From: Laura Gibbons <Laura.Gibbons@arun.gov.uk>
Sent: 18 May 2021 11:34
To: Planning.Responses <Planning.Responses@arun.gov.uk>
Subject: RE: Warwick Nursery, Eastergate - Amendments to Scheme- BN/153/20/PL

Engineers Further Comments Regarding Surface Water Drainage

- Arboricultural Method Statement – including updated site layout
- Flood Risk Assessment (23 April 2021 Amendment)
- Drainage Strategy drawing – Drawing No. 10635/1101 Rev. P9

Drawing Title
Proposed Site Layout

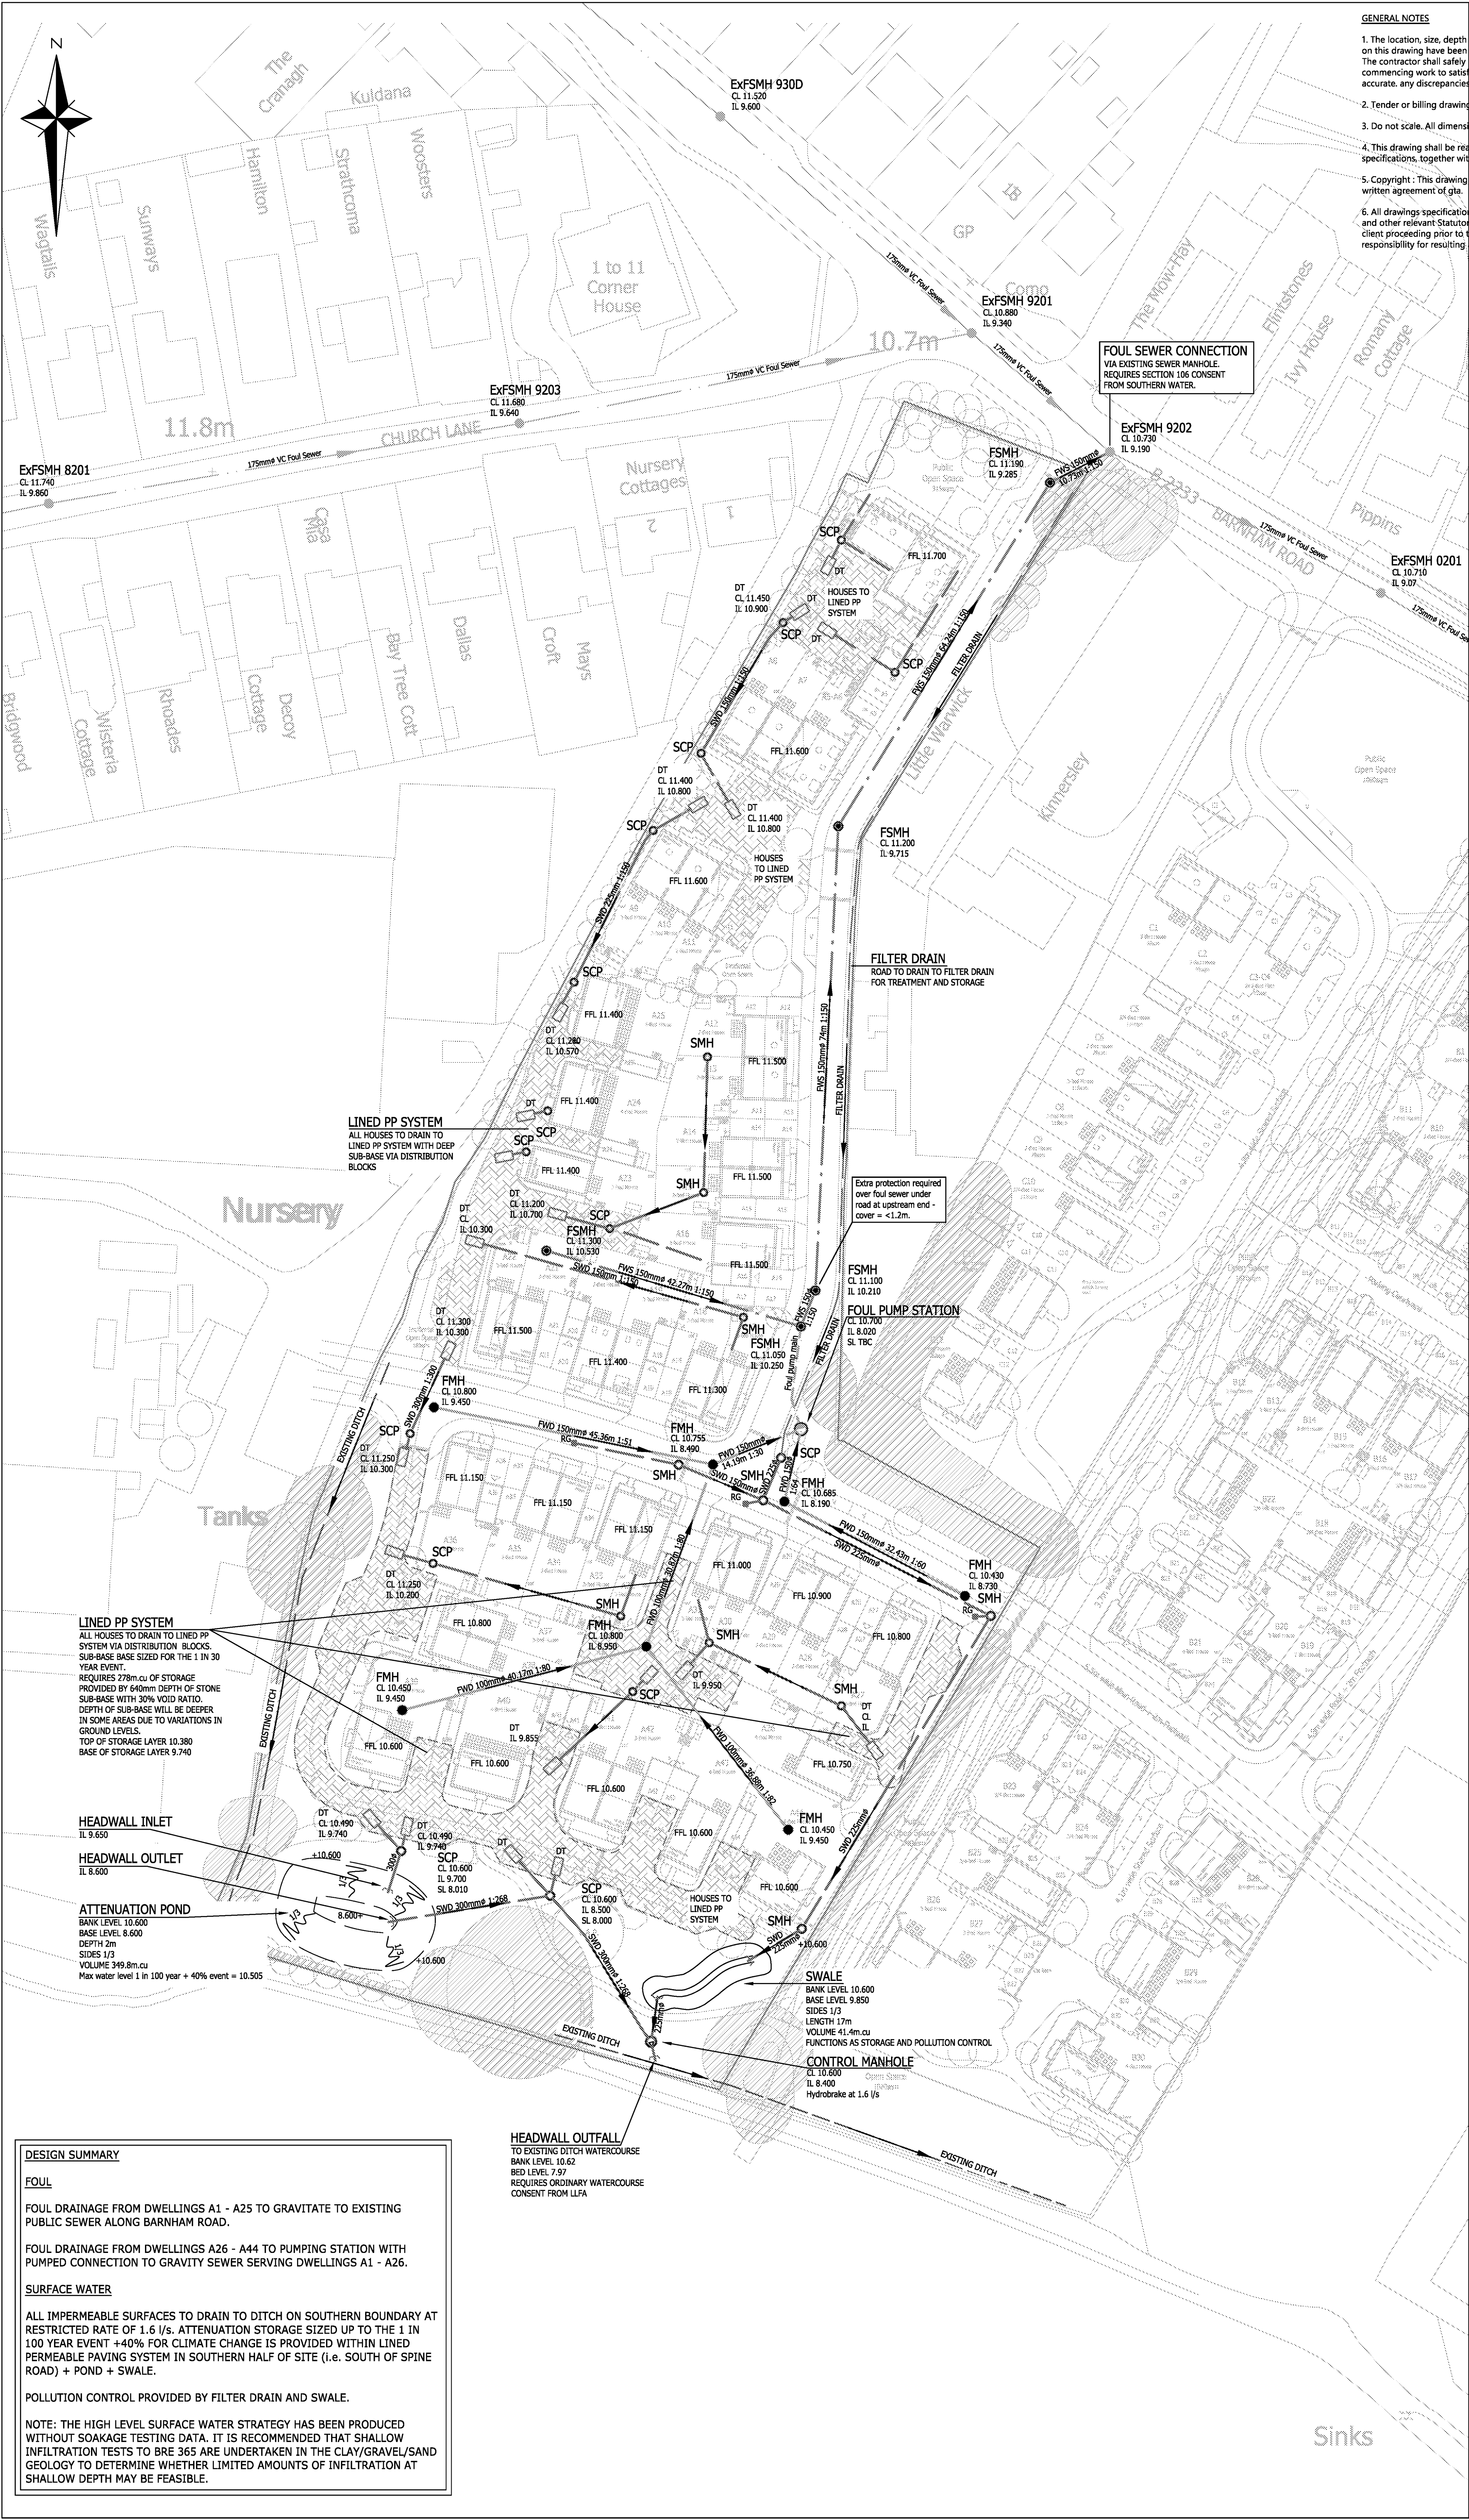
The drainage proposals include using infiltration only. Due to the presence of high groundwater in the south of the site there are proposals to land raise. We note that the areas that are proposed to be land raised extend into tree protection areas, we therefore recommend that the council's tree officer is consulted on these proposals.

The southern infiltration basin extends slightly within the RPZ, and therefore will need to be reviewed. We have further concerns about the likelihood that greater surface water drainage volume and space will be required. Our concerns are based on the following:

- The infiltration blanket has been calculated with a greater depth than available in reality, it will need to be modelled with a cap volume depth;
- An inadequate factor of safety is currently used in design (factor of safety of 2 currently used in design, a factor of safety of 6.5 is likely to be required);
- incoming invert levels to infiltration structures are not currently set above the 1 in 10 year plus cc water level, as required by policy;
- insufficient freeboard currently provided to the basin (160mm currently provided, 300mm minimum is required above peak water level); and
- some soakaways elsewhere on site fail to meet minimum easement requirements (5m to buildings and highways, 2.5m to property boundaries is required)

As a result we cannot be 100% certain at this time that the layout as currently proposed will be deliverable. We believe that there is a chance that not just details but the method of surface water disposal may need to be altered in the southern portion of the site. Land raising in order to make infiltration viable may conflict too much with other disciplines and in which case there is a strong argument for altering the strategy to attenuate surface water before restricted discharge to the watercourse at the south of the site.

As noted above there are wider issues with drainage strategy as currently proposed which extend beyond the southern network. Generally the application of infiltration rates and factors of safety in design need to be reviewed. The position of soakaways need to be adjusted to ensure minimum easement requirements are achieved.
